WEST SUSSEX COUNTY COUNCIL CONSULTATION

TO:	Arun District Council FAO: Simon Davis
FROM:	WSCC - Highways Authority
DATE:	10 February 2022
LOCATION:	The Cottage Shripney Road Bognor Regis PO22 9PA
SUBJECT:	BE/176/21/PL Demolition of existing dwelling and ancillary outbuildings and erection of a 66-bedroom care home with associated access, parking and landscaping. This site is in CIL Zone 3 (Zero Rated) as other development & is a Departure from the Development Plan. Amended Visibility Plans and New Footway Plan received on 4th Feb 2022.
DATE OF SITE VISIT:	Location known to Officer
RECOMMENDATION:	Advice / No Objection
S106 CONTRIBUTION TOTAL:

Drawing:
2109058-02A

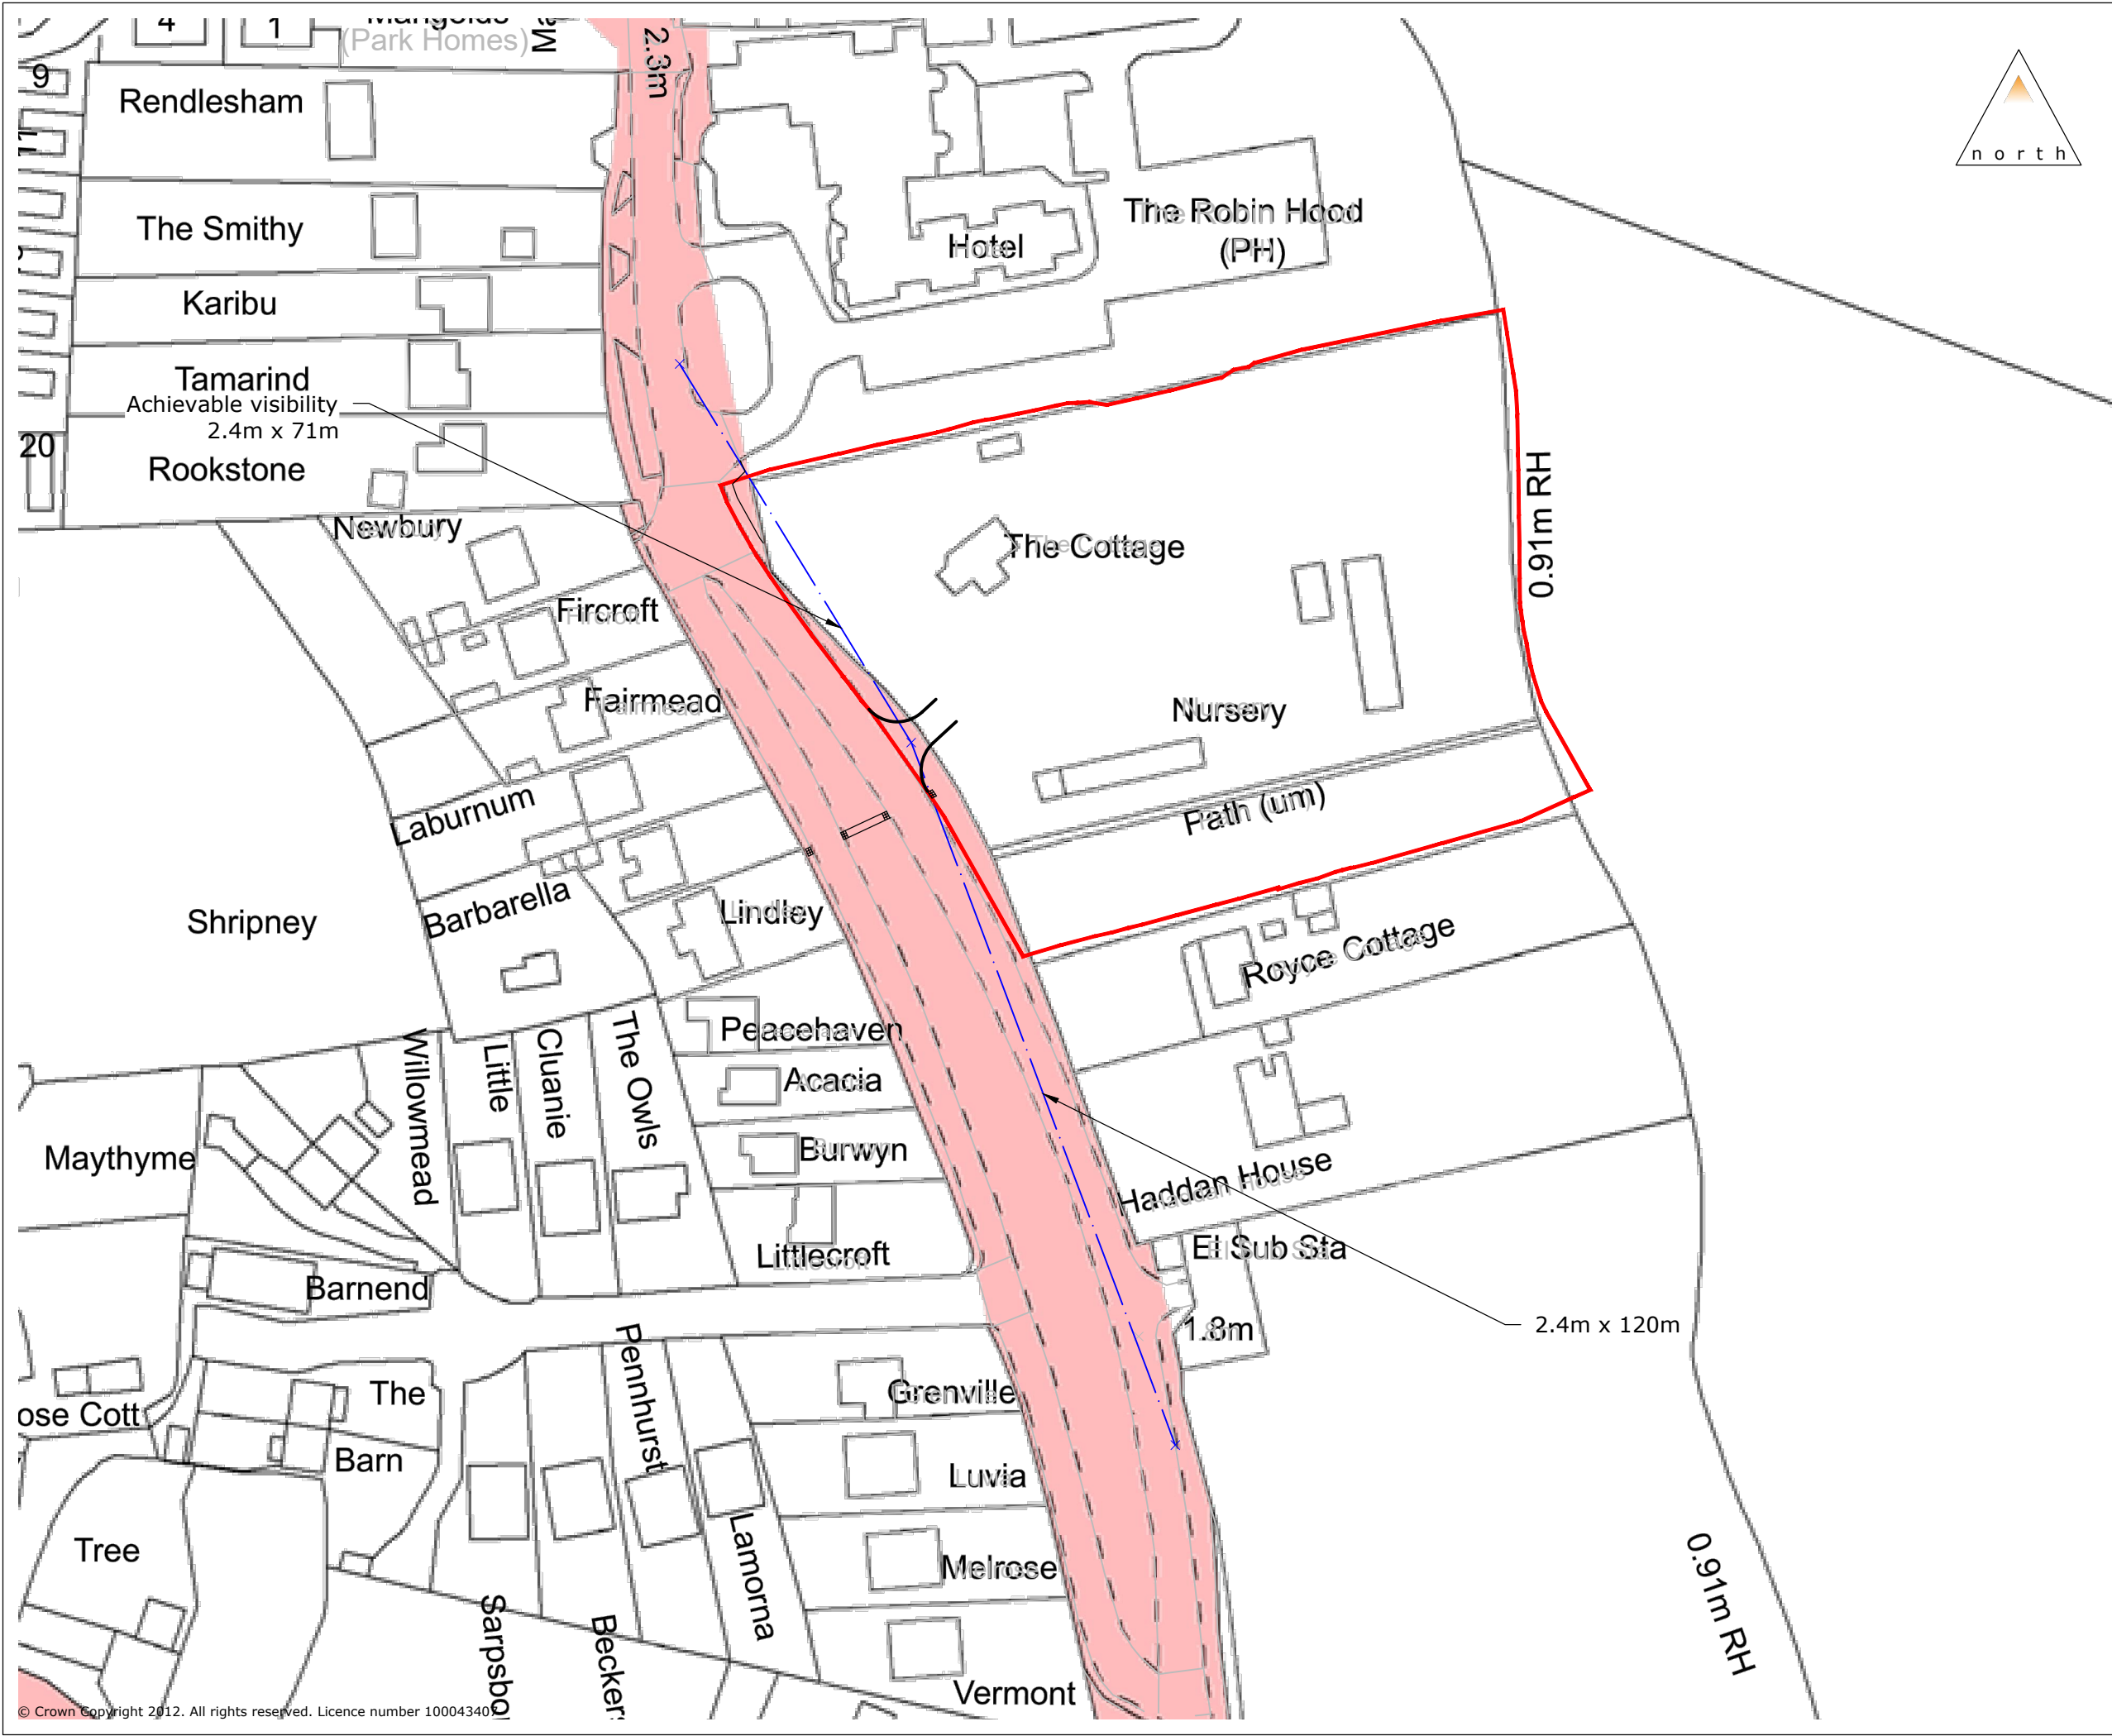
As the proposal would be less intensive than that previously approved there would be no requirement for changes to the access design. Access and visibility will remain as approved, and this will be acceptable to serve the proposal.

No part of the development shall be first occupied until such time as the vehicular access serving the development has been constructed in accordance with the details shown on the drawings 2109058-05, 2109058-06 & 2109058-07
